Consultation Response from KC,
Trees

2024/93489 land north of, Paul Lane, Flockton, Huddersfield, WF4 4BP

Erection of agricultural building, formation of new internal road and yard, re-grading of land, provision of landscaping and associated works

Date Responded: 07/01/25

Appendix 2. Tree Assessment Plan

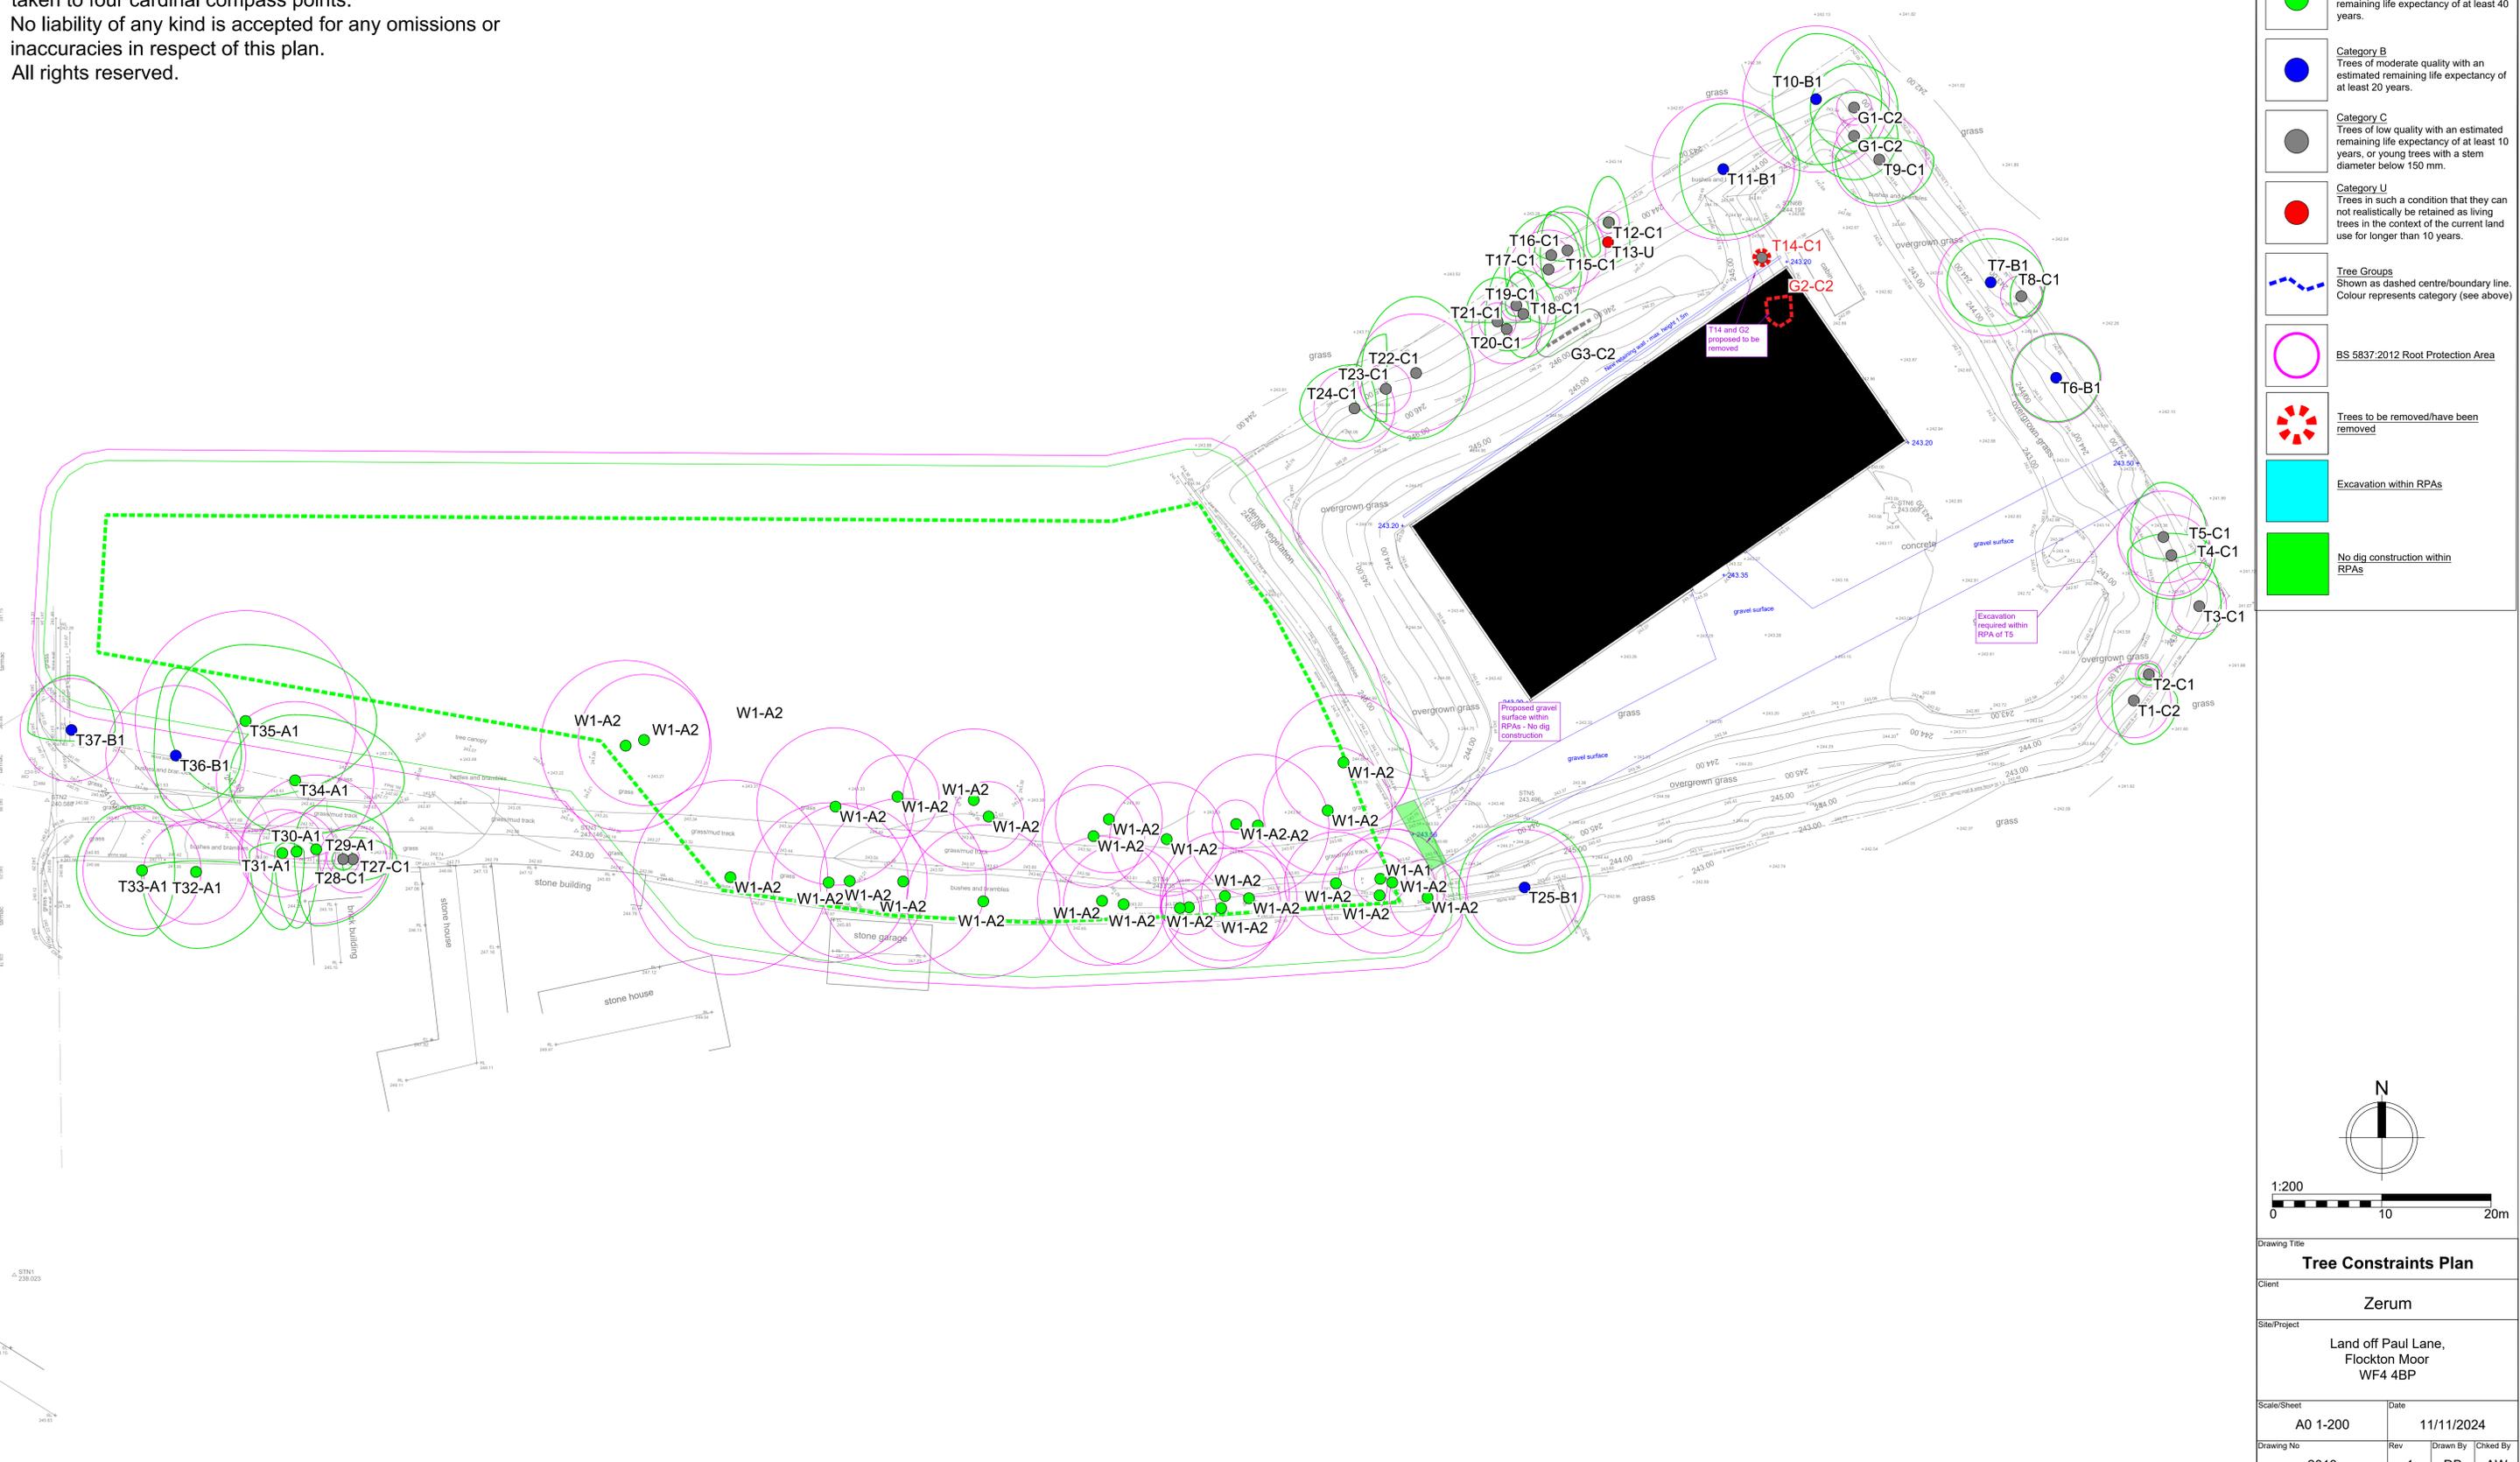
The proposed removals of T14 and G2 are acceptable, with 1:1 replacement planting in a suitable location within the site. The replacement planting should comprise species reflective of the trees which were lost, such as sycamore and silver birch.

It is understood that the proposed gravel track would encroach on the root protection areas of T5 and two trees from within W1.

To minimise damage to the roots of trees, root pruning of T5 is acceptable and should be carried out under arboricultural supervision.

It is also acceptable for no-dig construction methodologies to be used within the proposed road which overlaps with the RPAs of the two trees from W1. We expect the impact of this to be low, where the new gravel surfacing is positioned on top of the existing dirt track.

In summary, we find no objection from an arboricultural perspective with the proposed layout, but we would seek to condition an arboricultural method statement (AMS) and tree protection plan to show how the retained trees will be protected throughout development.
